Department of Planning and Environment

Each issue raised in the Department's letter is addressed in detail in Section 2 of the Response to Submissions.

Sydney Olympic Park

Drawing no. **DA02.001** Revision **A**

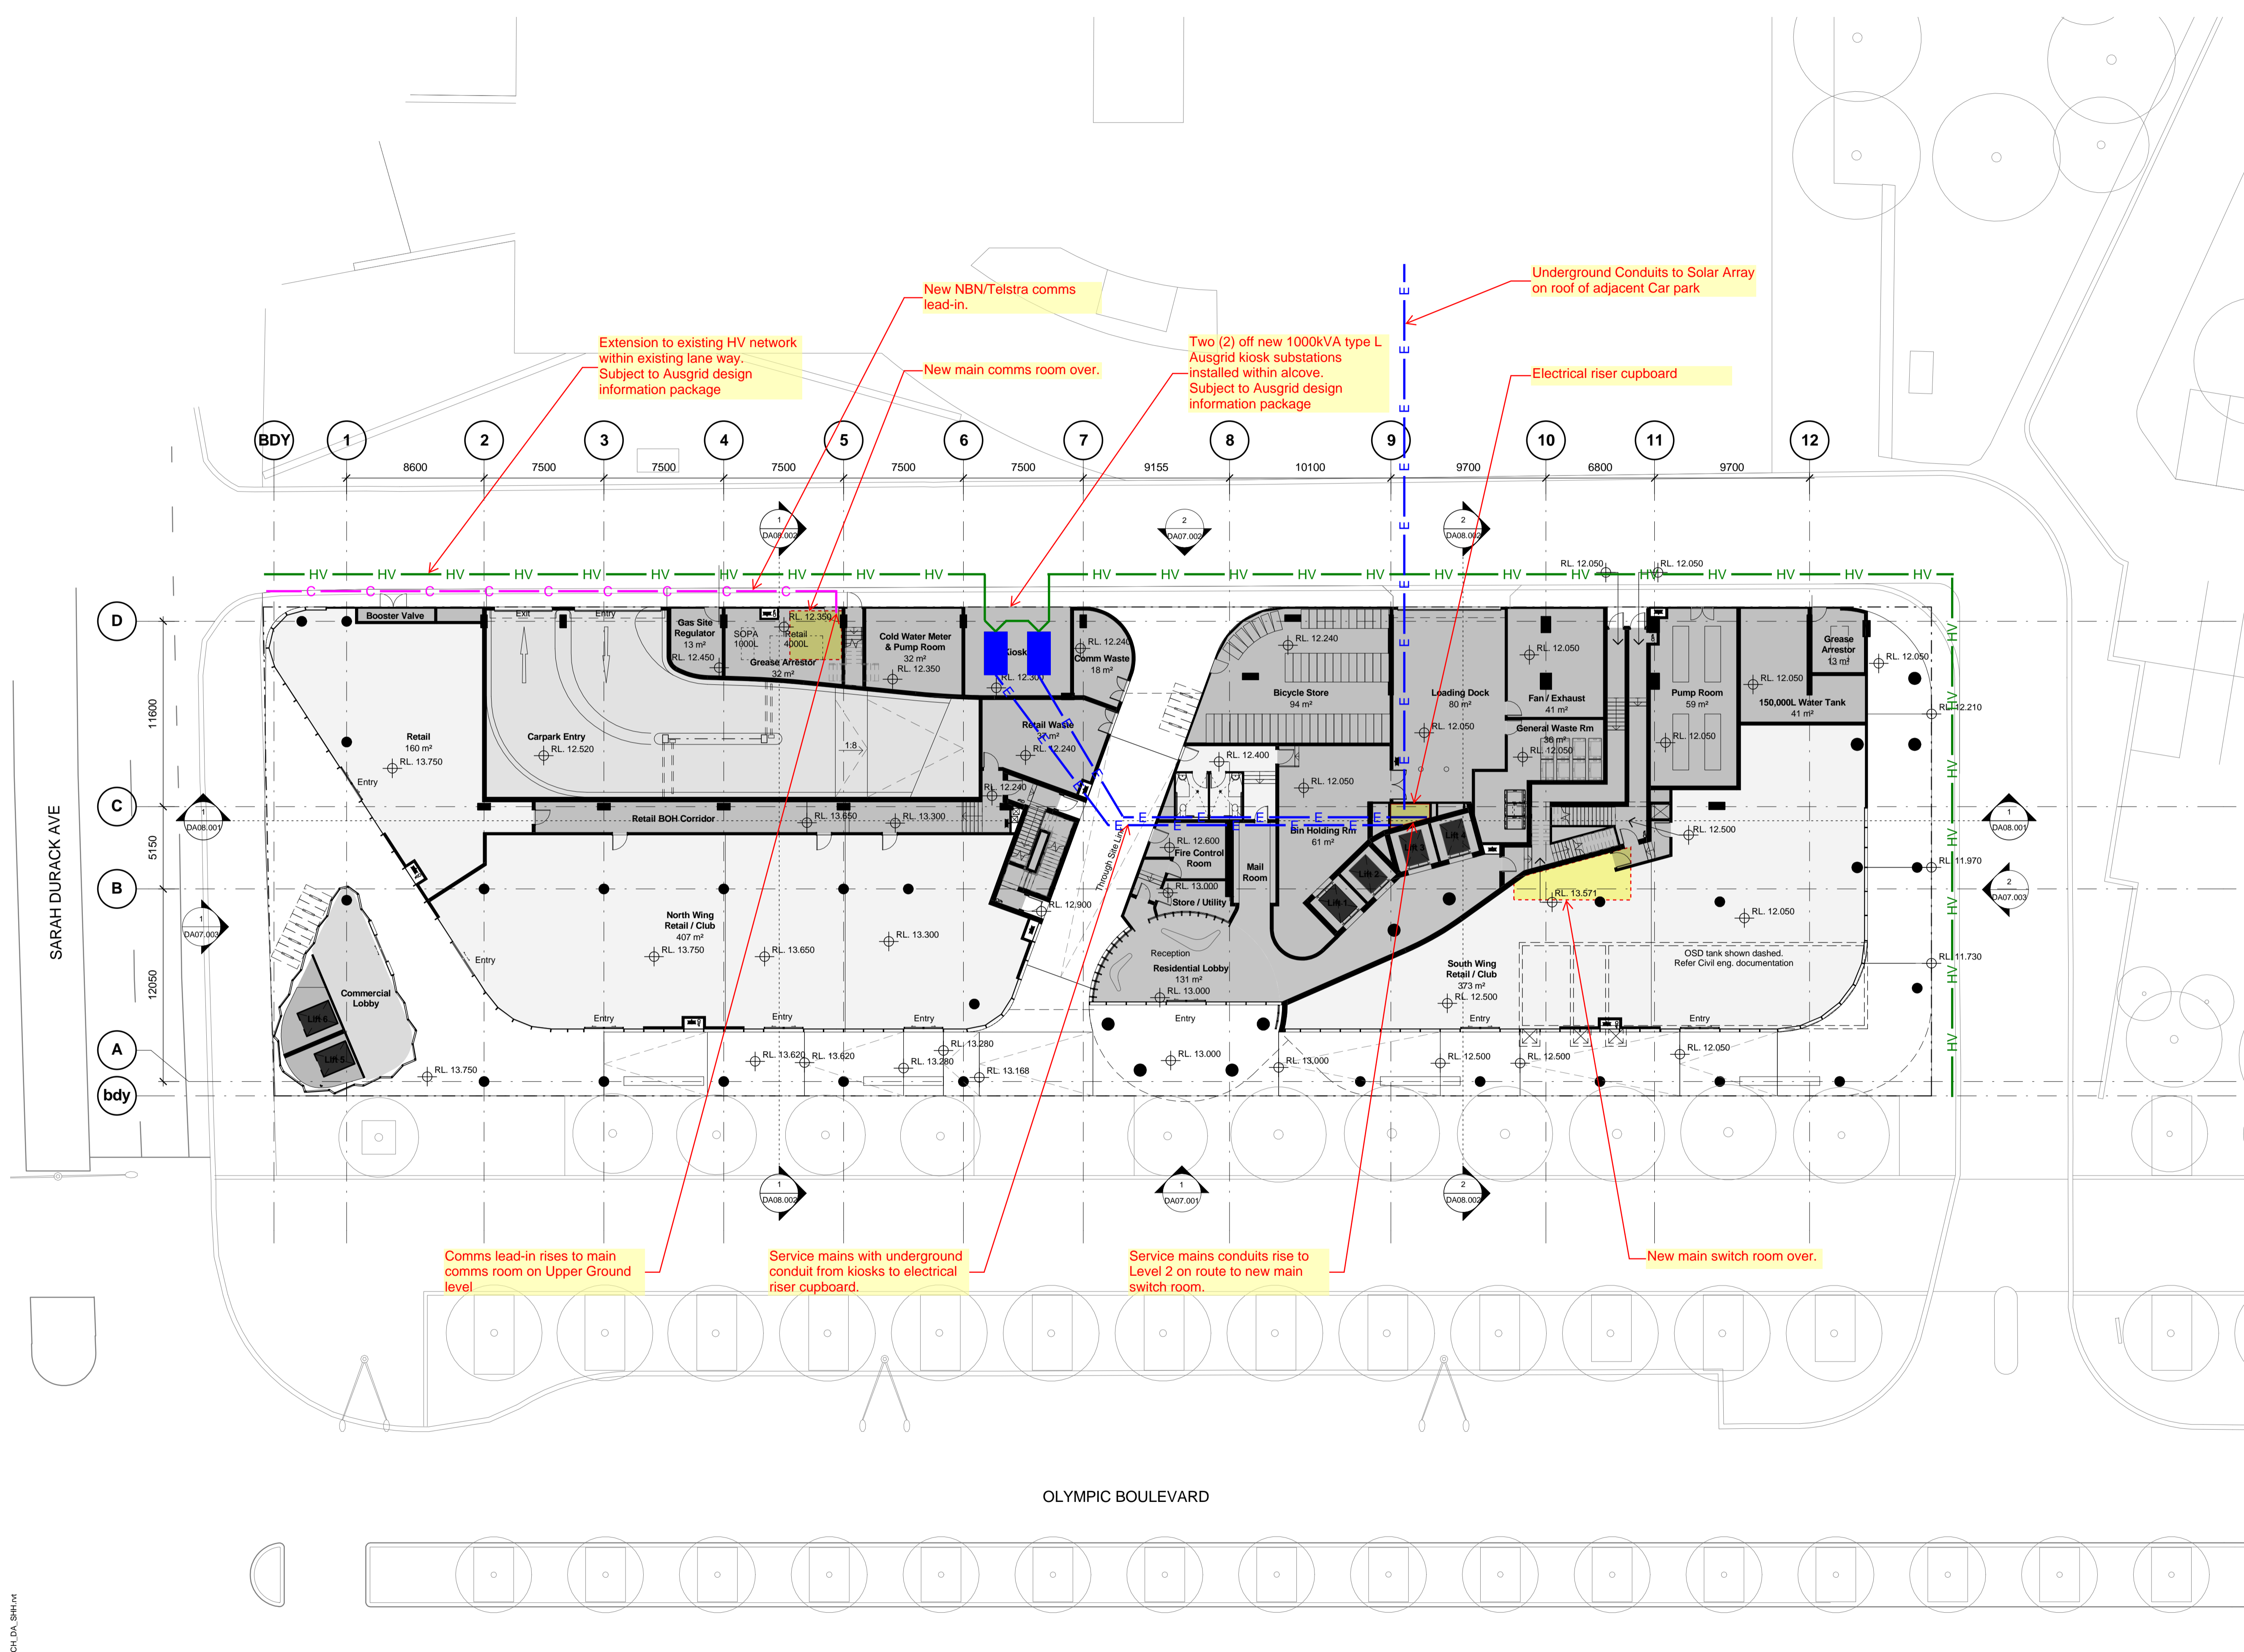
| Recommendation/issue | Comment |
|---|---|
| <p>1. Ground level plant/services</p> <p>The ground level of the building is heavily encumbered with plant and services which occupy more than 50% of the ground level frontages. These impact on the size of ground level retail tenancies and the residential lobby and create long stretches of bland and inactive frontages in areas where high pedestrian use is expected.</p> <p>Recommendations:</p> <ol style="list-style-type: none">1. Consider increase activation of ground level floor space, particularly along the through site link. | <p>The design of the through site link and adjoining building has been refined to further increase activation. Additional retail / commercial tenancies are provided at the eastern corners of the site link, which will provide additional activation to the link. See Section 2.2 of the Response to Submissions.</p> |

The colonnade zone is not well integrated into the public domain, and is less likely to be active and usable as a result. Key concerns are:

- very few connections from the colonnade to the Boulevard's public footpath
- Barriers created by continuously landscaped planting beds and seating benches
- Residential lobby entry columns partially obstruct the path of travel along the colonnade
- No information on paving treatments and how it will be integrated with the existing Trihex, Eco- Trihex and asphalt paving at this corner.

1. Consider repositioning the 2 columns impeding the colonnade zone at the residential lobby entry, so that they are out of the path of travel.
2. Provide more frequent crossing points between the Hoop pines to connect the colonnade and the footpath. These should be in permeable paving i.e. Eco Trihex and could incorporate steps to resolve the substantial level changes in some areas.

The residential lobby entry columns have been designed and located in a different manner to the colonnade columns as an integrated way-finding measure. The proposed design shows the tower corner 'interrupting' the south podium facade in order to clearly delineate the residential lobby entrance at ground and provide an articulated facade along a long site frontage. The colonnade columns under the tower

serve to symmetrically frame the entry as well as to provide a sense of arrival for residents and visitors.

Electrical riser cupboard.
 Refer to typical layout
 arrangements on drawing
 DA02.010.

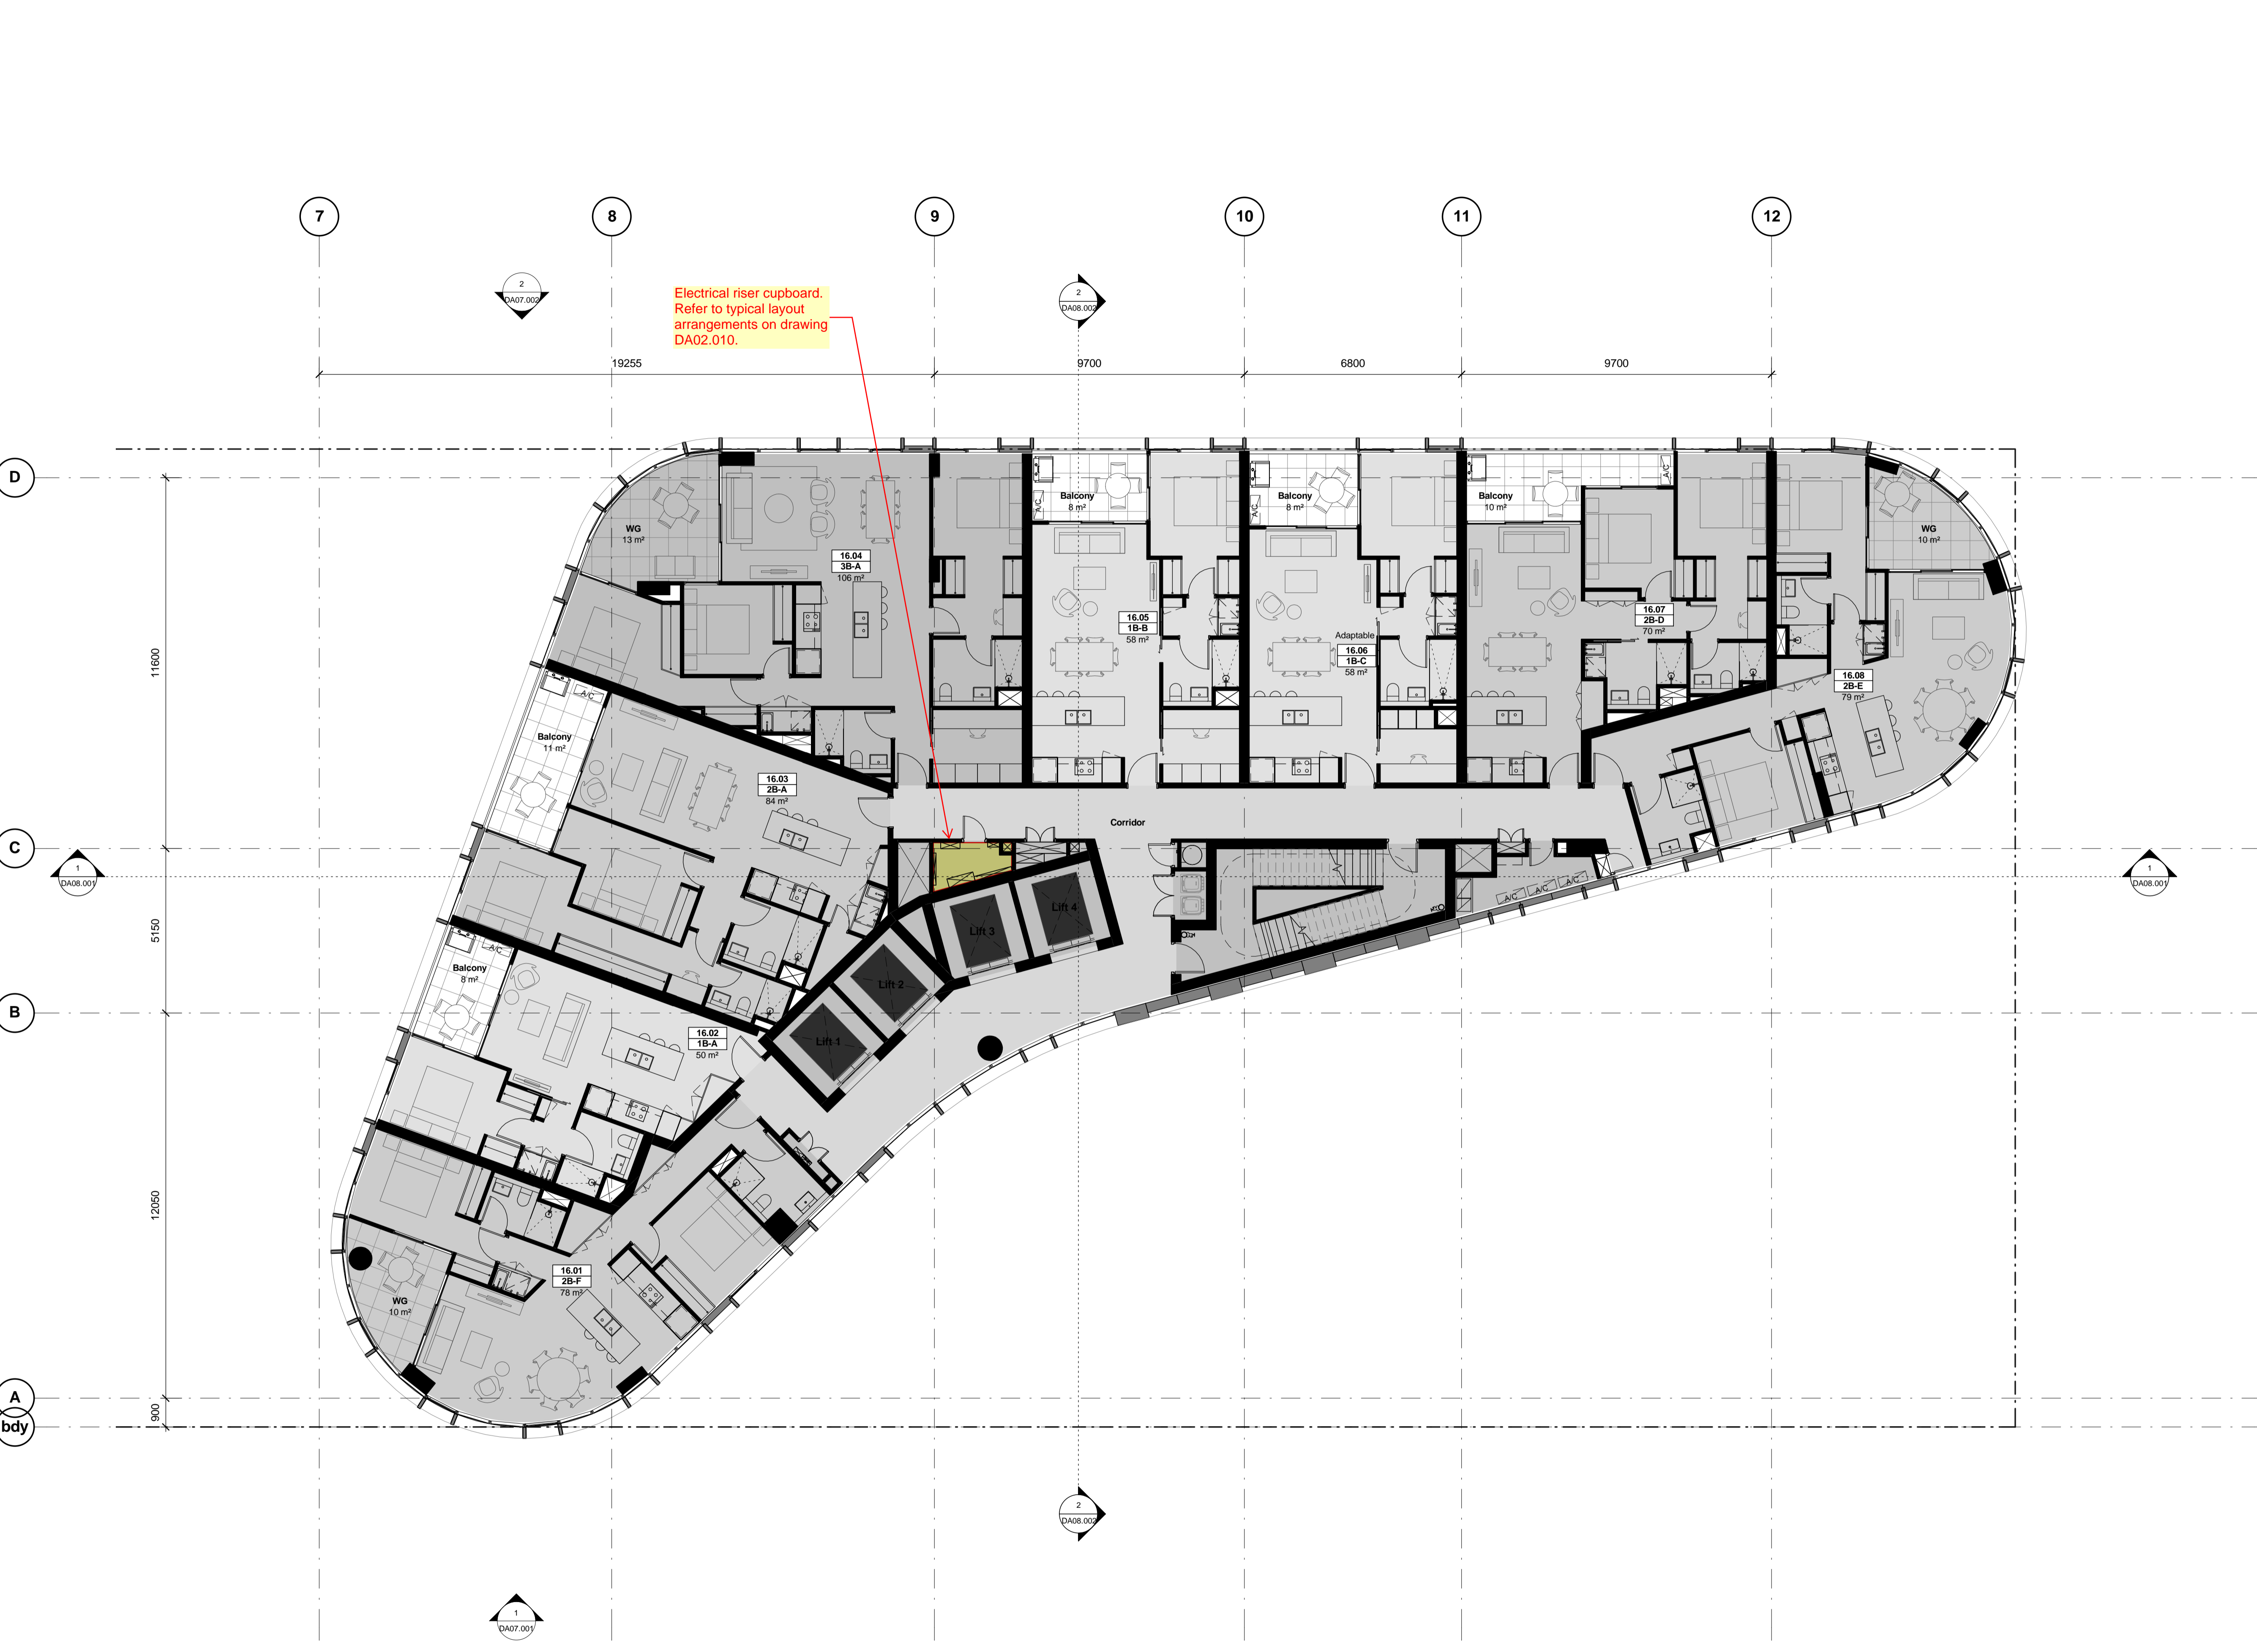
- that the narrow footprint design has not been better utilised to provide greater cross ventilation, as only two of the eight apartments per floor have dual frontage to provide for cross ventilation.
- Most of the apartments on each floor have AC condenser units on the balconies. This is no longer considered to be good practice as it reduces the usability of the balconies.
- Given the fire stair has a large external wall surface and is generously proportioned, it has the potential to be better utilised on a daily basis by residents, especially if there were windows or viewing panels in the outer wall.

1. Where possible seek to maximise the number of dual frontage apartments.
2. Incorporate a 'natural stack' ventilation system with registers to the rear of apartments i.e. near the kitchen, entry hall and bathroom areas for single orientation apartments.
3. AC condensers to be located away from balconies - consider enlarging the AC condenser rooms on every floor to accommodate the needs of the entire floor.

The current condenser room located on each floor of the tower cannot accommodate additional condensers, due to spatial constraints and heat impacts rising up the tower. In order to accommodate additional condensers, the floorplate would need to be increased with the condenser room protruding out from the tower massing to provide sufficient air intake / outtake openings within the facade. The AC condensers located on balconies will be screened to mitigate visual impacts. It is noted that this approach has been applied to the completed Australia Towers development and the approved Site 68 development.
